October 29, 2024

**Re: Response to Technical Comments – SPC Application D07-12-24-0087; 2900 Brian Coburn Blvd./119 Ryan Reynolds Way**

40 YEAR CANOPY PROJECTION

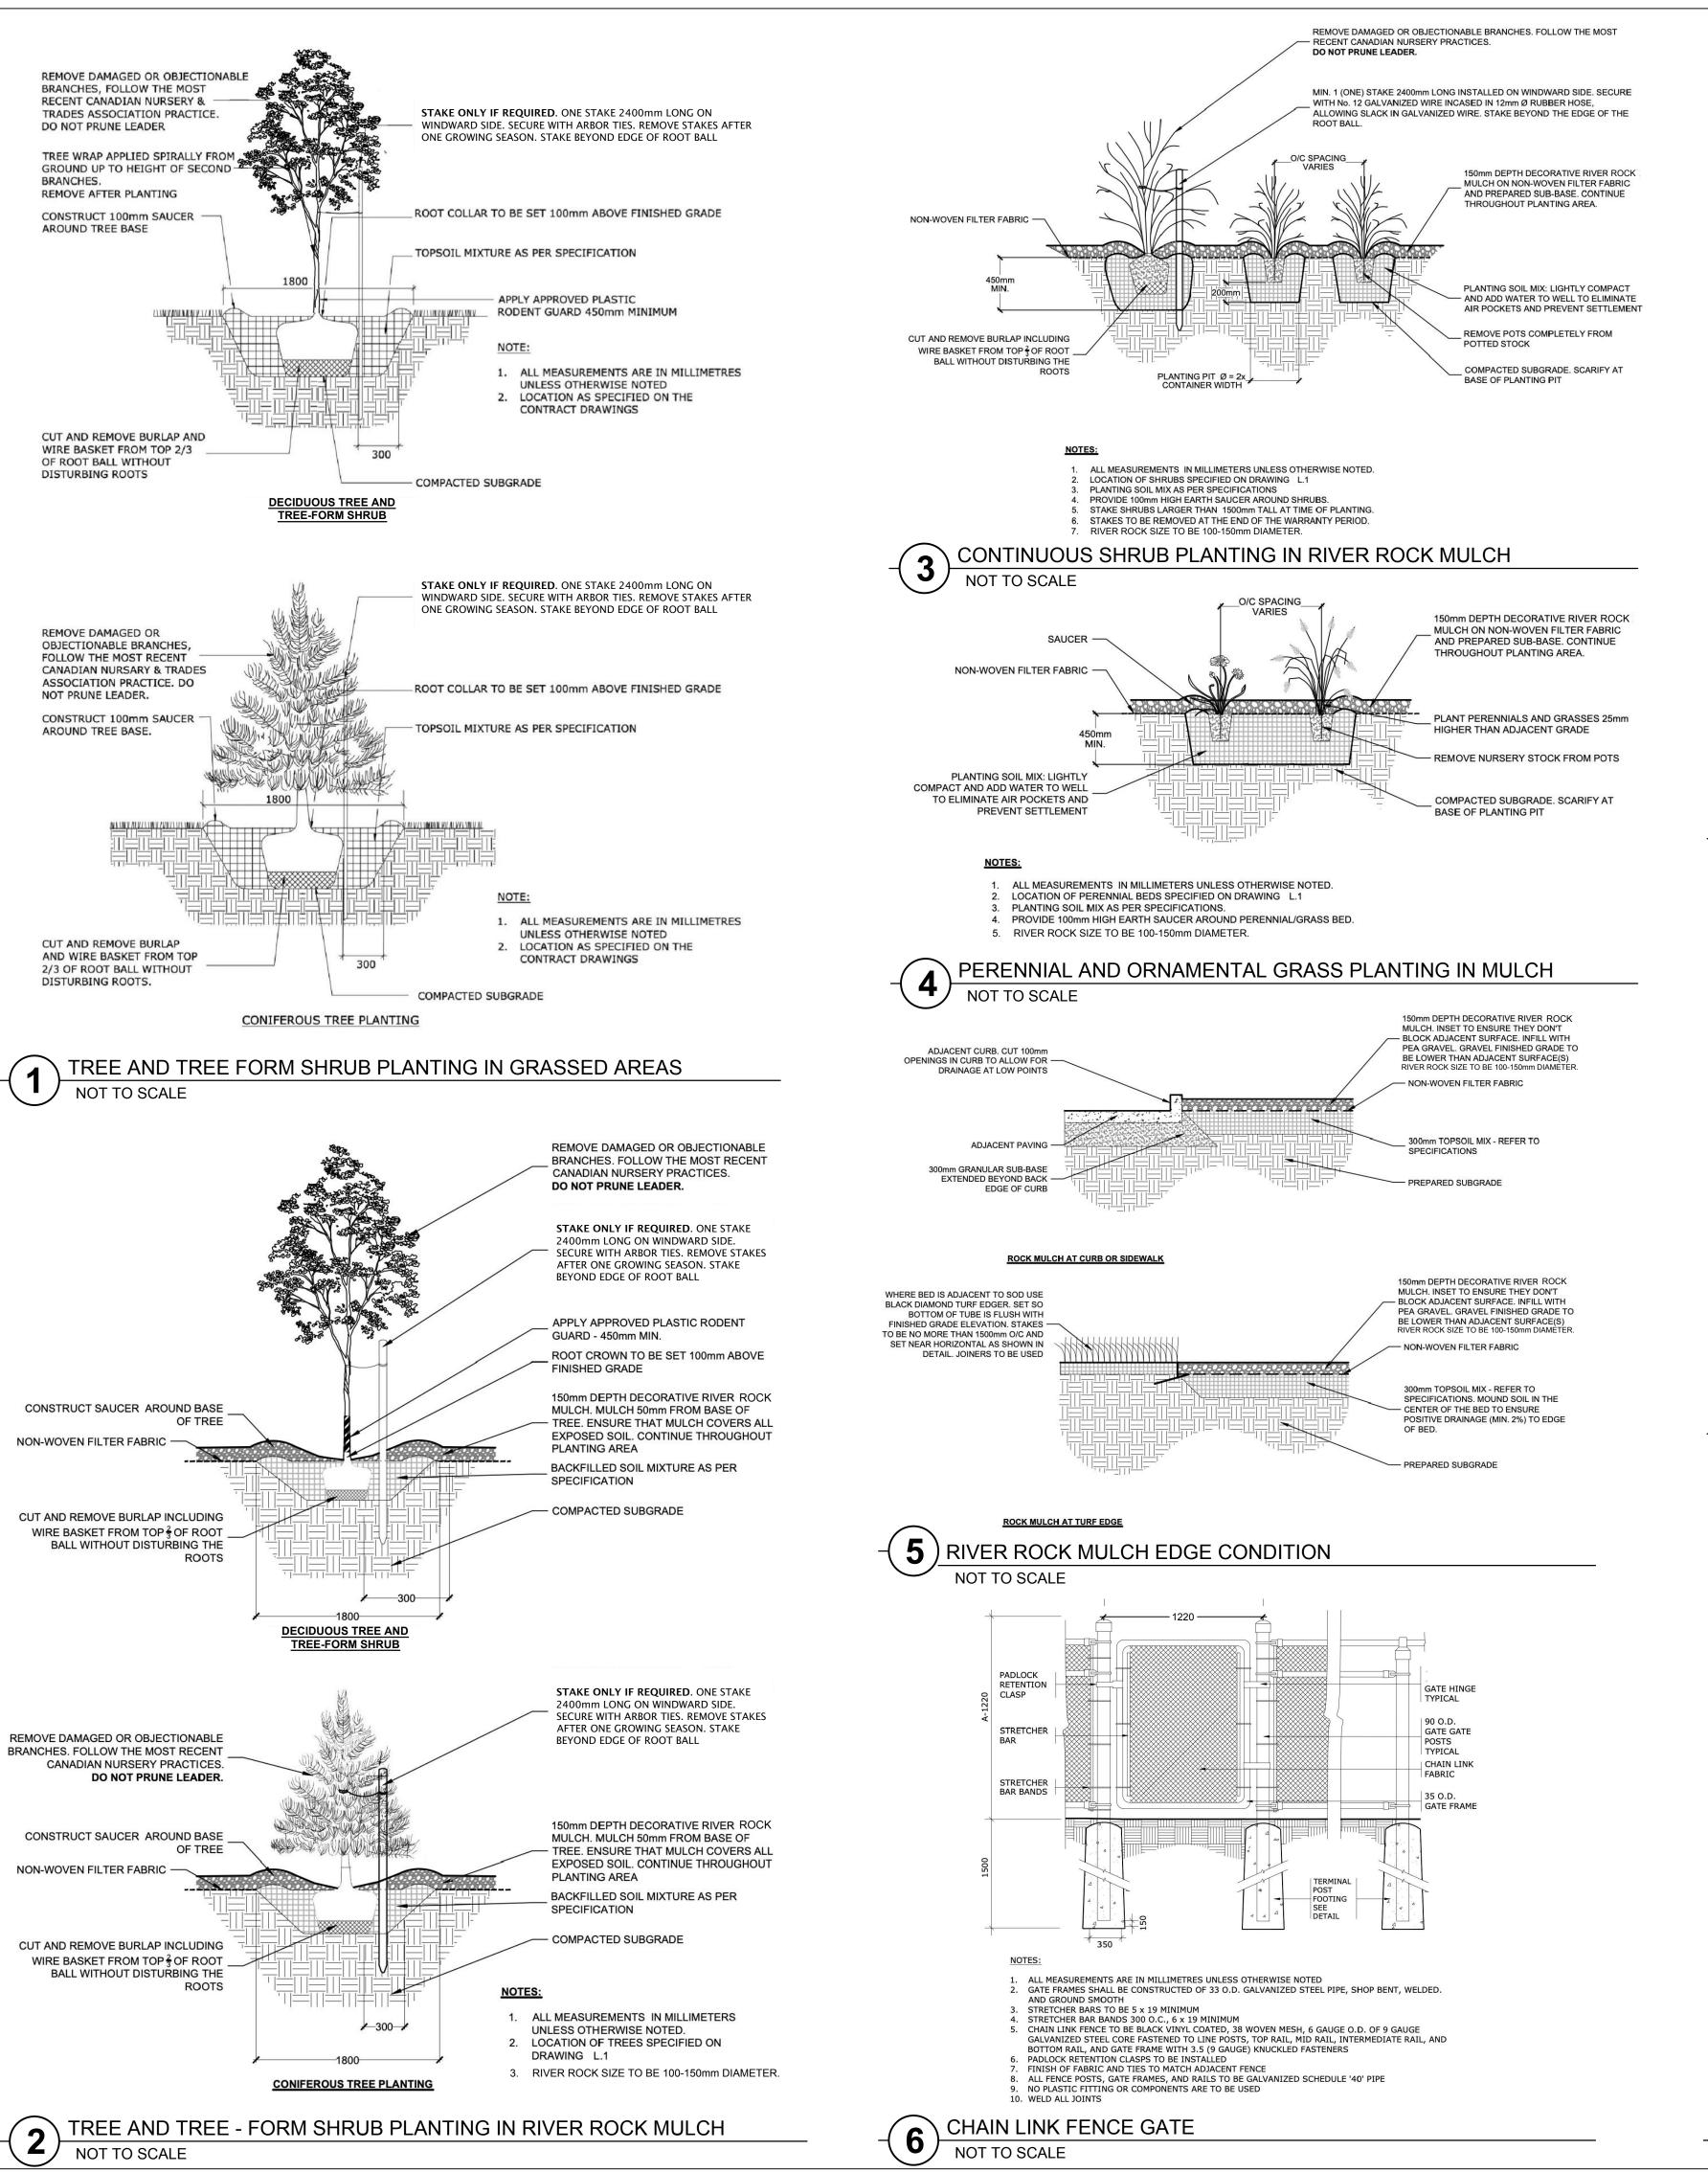
VI. Forestry	
Comments:	
18. The scale bar is not shown on the Tree Conservation Report or the 40-Year Projection. On the Landscape Plan, the scale of the map doesn't align with the projection, creating skewed measurements during review.	Noted. Scale bar and viewports were reviewed. No errors detected. All plans have a scale bar.

TREE PROTECTION FENCING

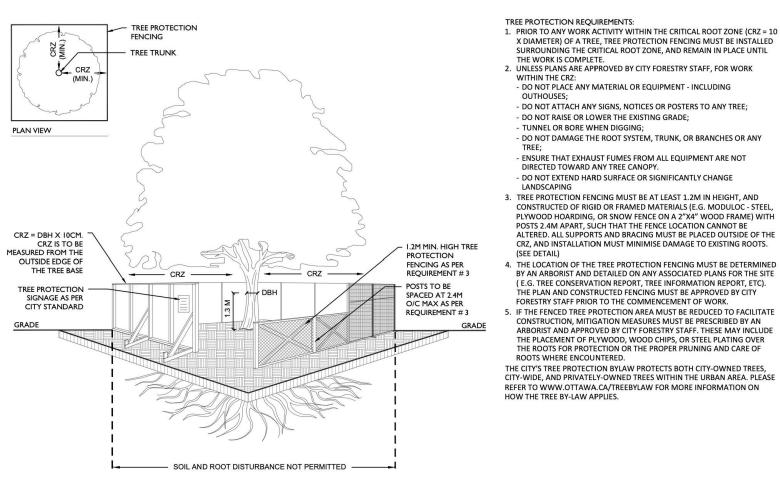
<p>Geotechnical Report. Existing City trees must be designed around.</p>	
<p>22. Does the Qa (large tree) proposed in the City of Ottawa right of way off Brian Coburn meet the Geotechnical Report setback requirements? Does being separated by a drive isle influence the separation distance?</p>	<p>The Quercus alba that has been specified has been set back to the mature height of the tree (approximately 22m).</p>
<p>23. There is a conflict between a proposed watermain and tree #10. Locate the water service 1.5m from existing trees. Photo included for reference:</p> 	<p>Noted. The watermain connection cannot move 1.5m away from the existing trees. Tree #10 is proposed to be removed to accommodate the watermain line. The protective fencing has been updated on the plans.</p>
<p>24. The tree protection fencing cannot be removed to facilitate construction. Locate tree protection so it can be maintained in place for the duration of construction. For example, adapt the tree protection fencing along Brian Coburn that conflicts with water main installation. Photo included for reference:</p> 	<p>The tree protection fencing has been revised to reflect the attached image.</p>
